Submission Opposing Project Mars Data Centre Development

Application Reference: SSD-82052708

Submitted by: Resident of Wood Street, Lane Cove West NSW 2066

2 20TH MARCH - 12PM - PROPOSED
 1 : 2000

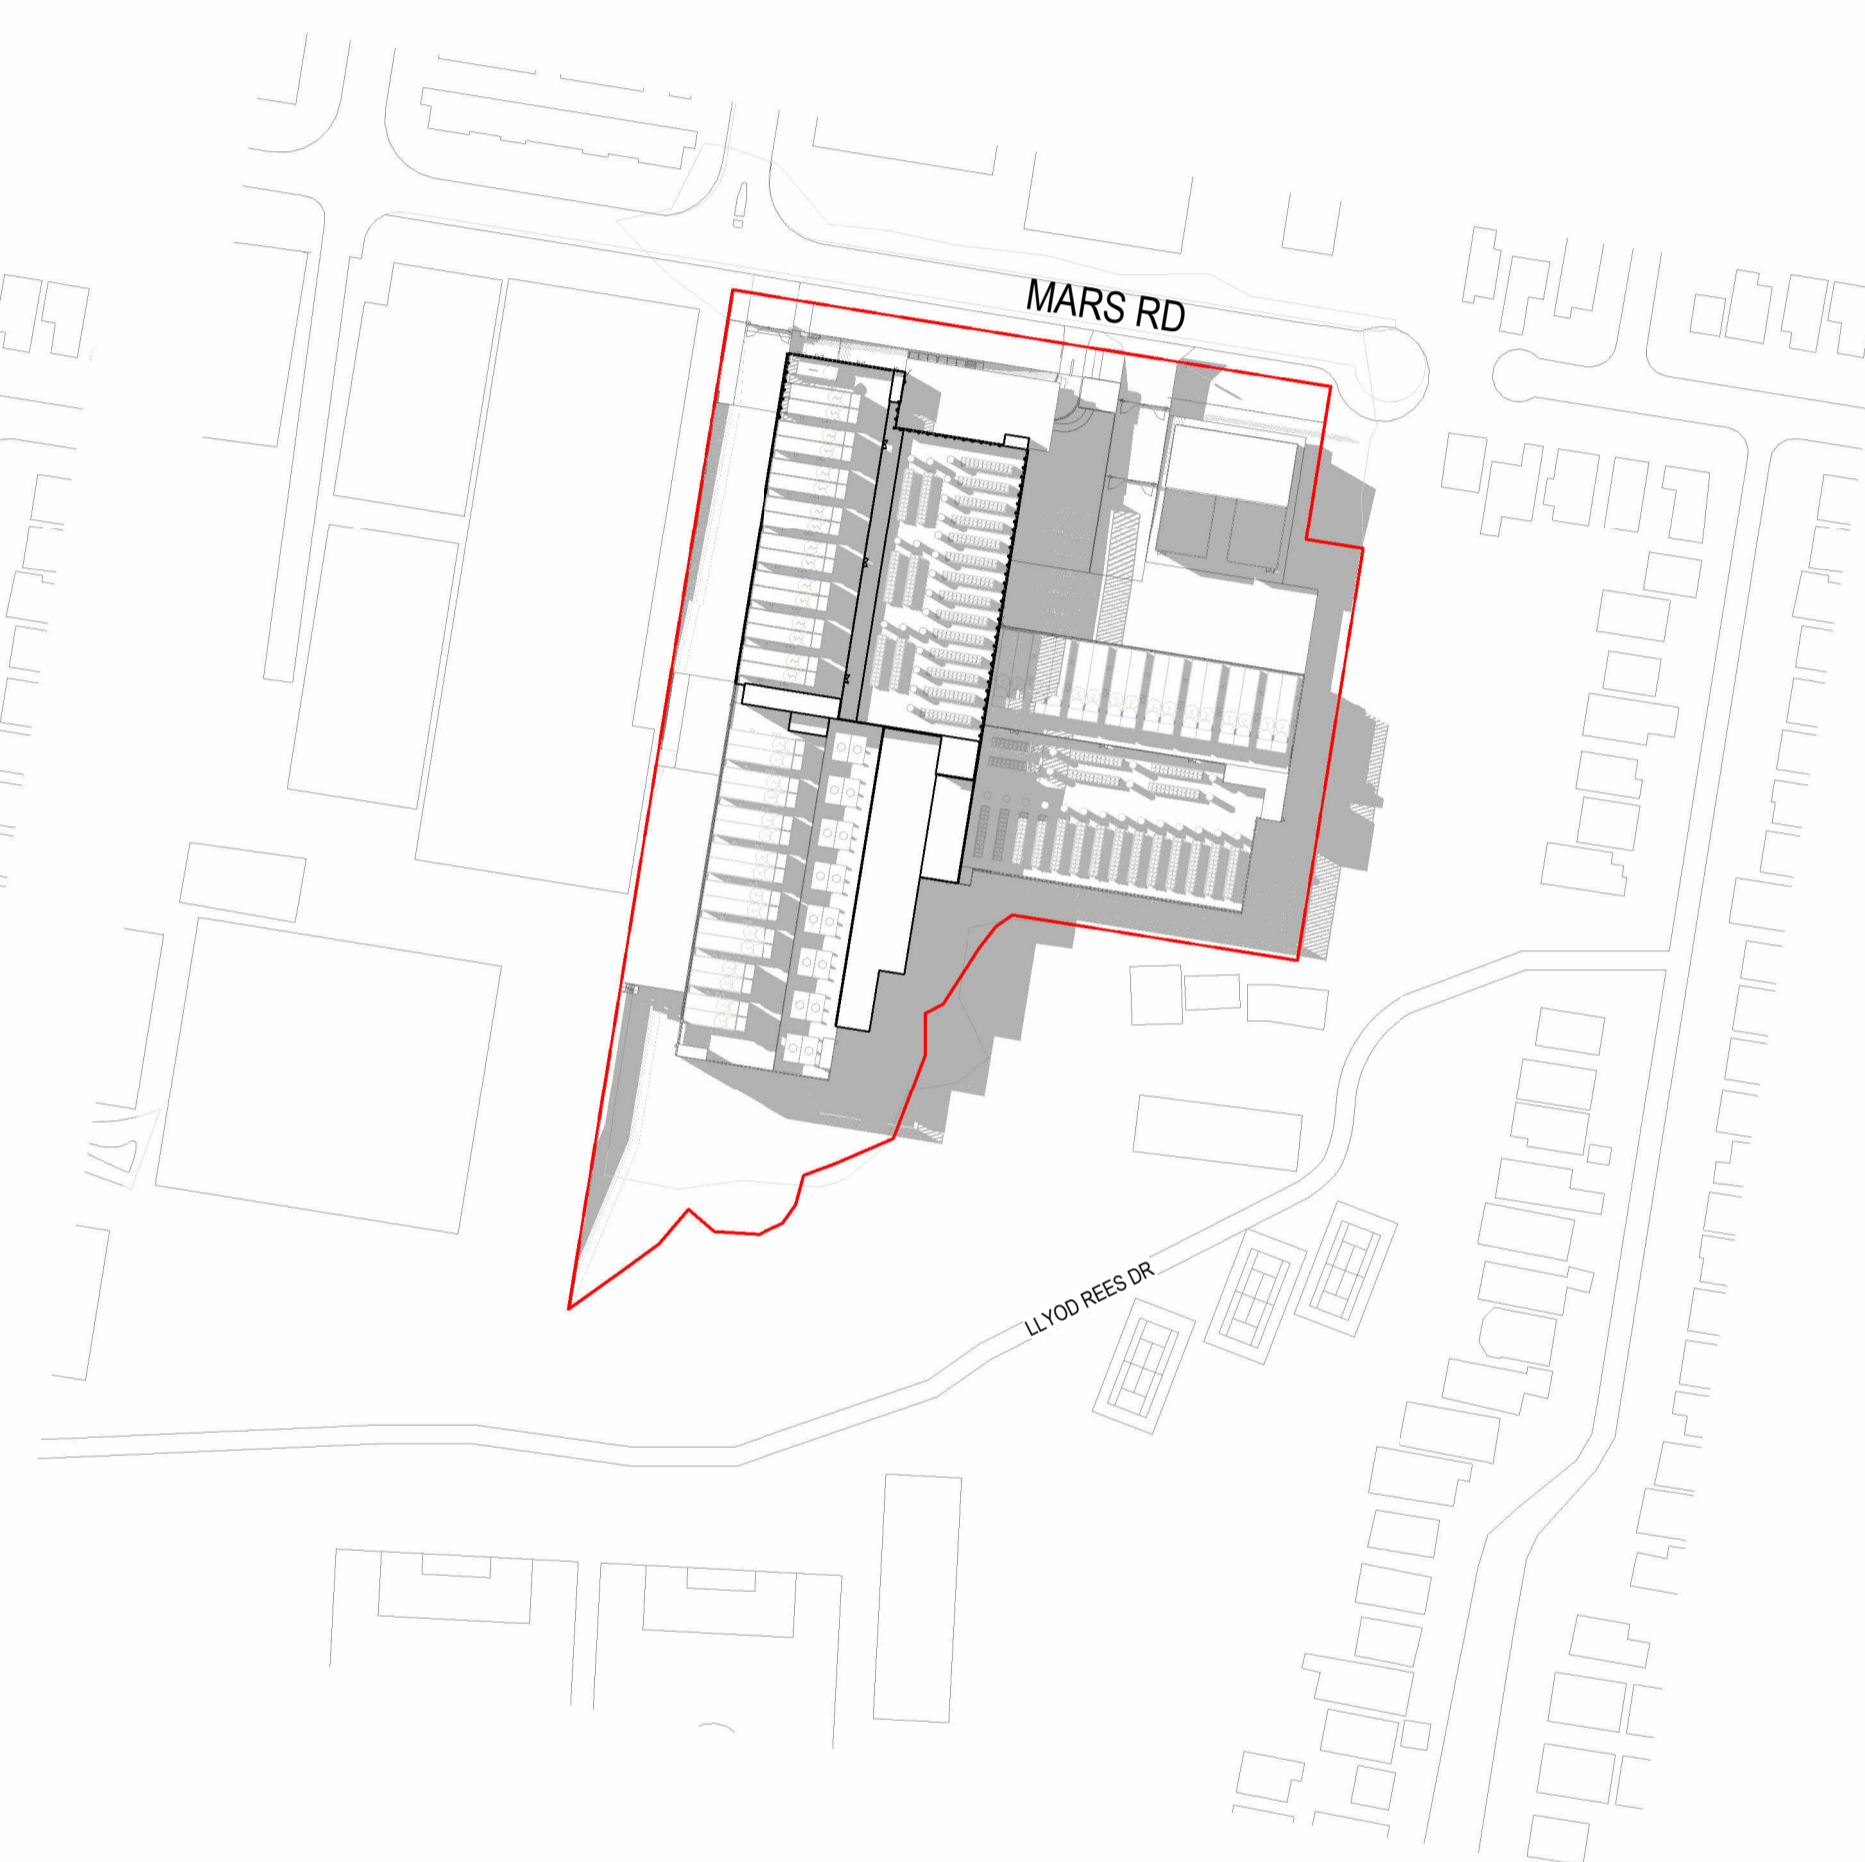
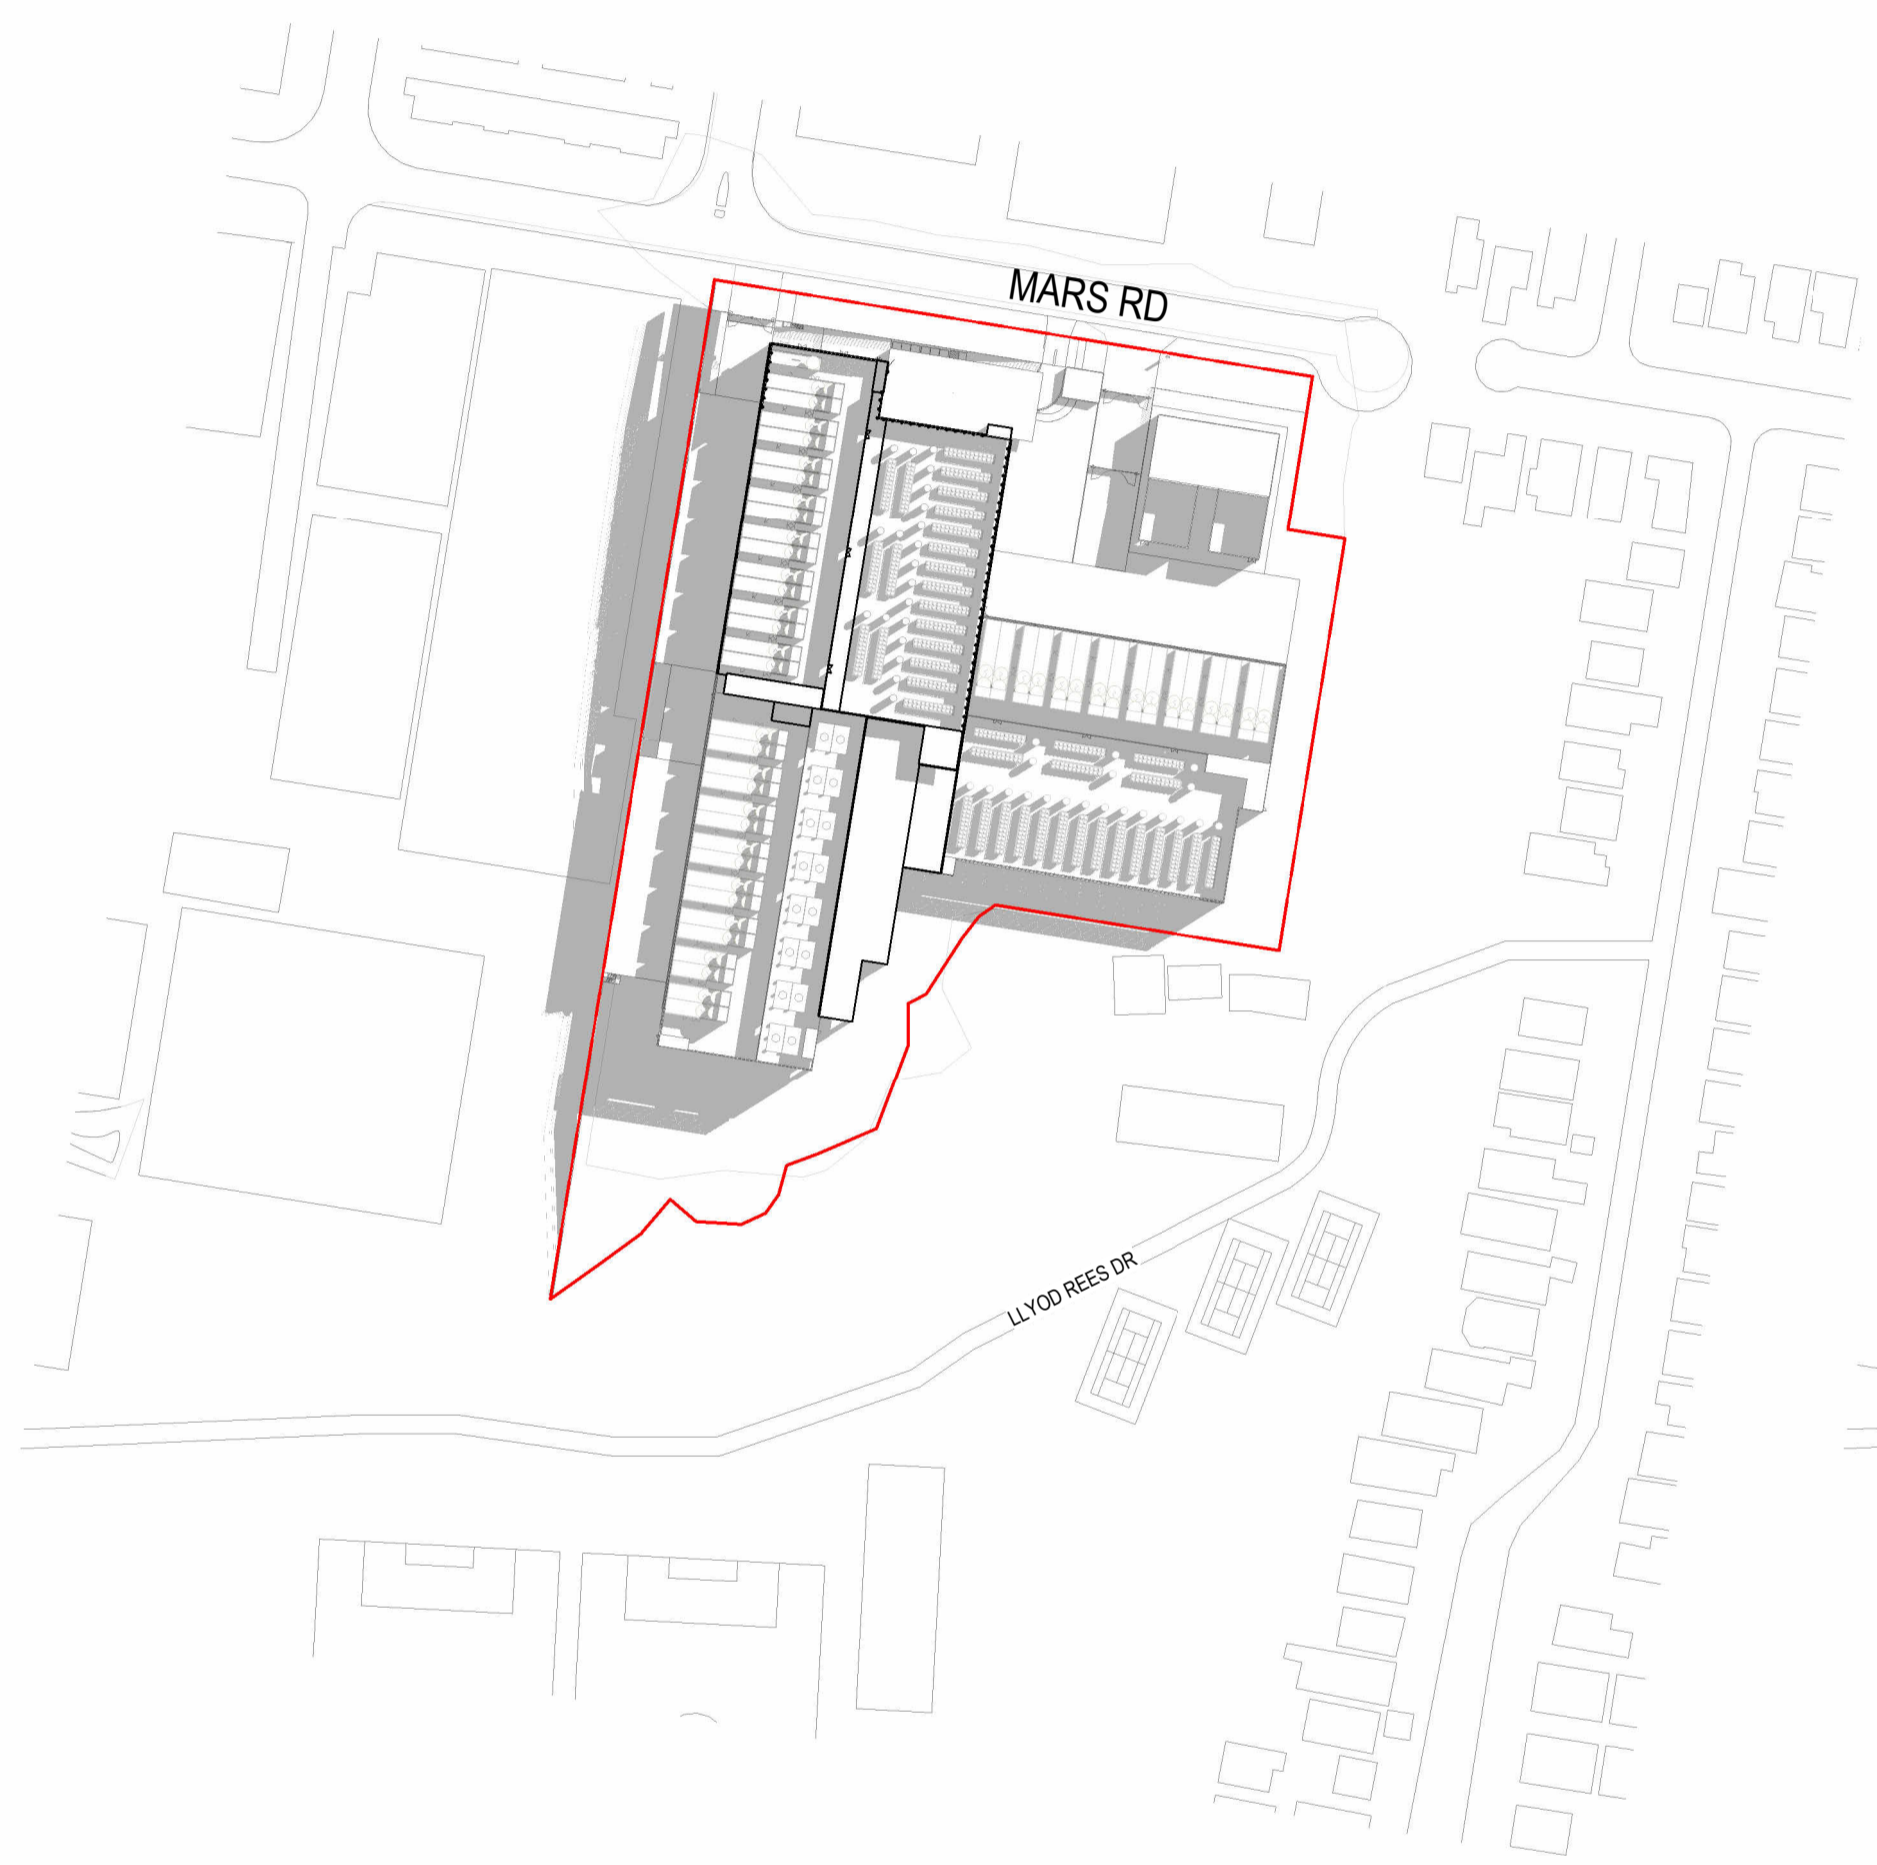
The EIS visual impact assessment uses a limited selection of viewpoints and computer-generated imagery. There are no detailed overshadowing diagrams

demonstrating impacts on Blackman Park across different seasons and times of day. There is no analysis of the loss of residential privacy for homes on Wood Street and surrounding streets, or of the loss of solar access to neighbouring properties and the park.
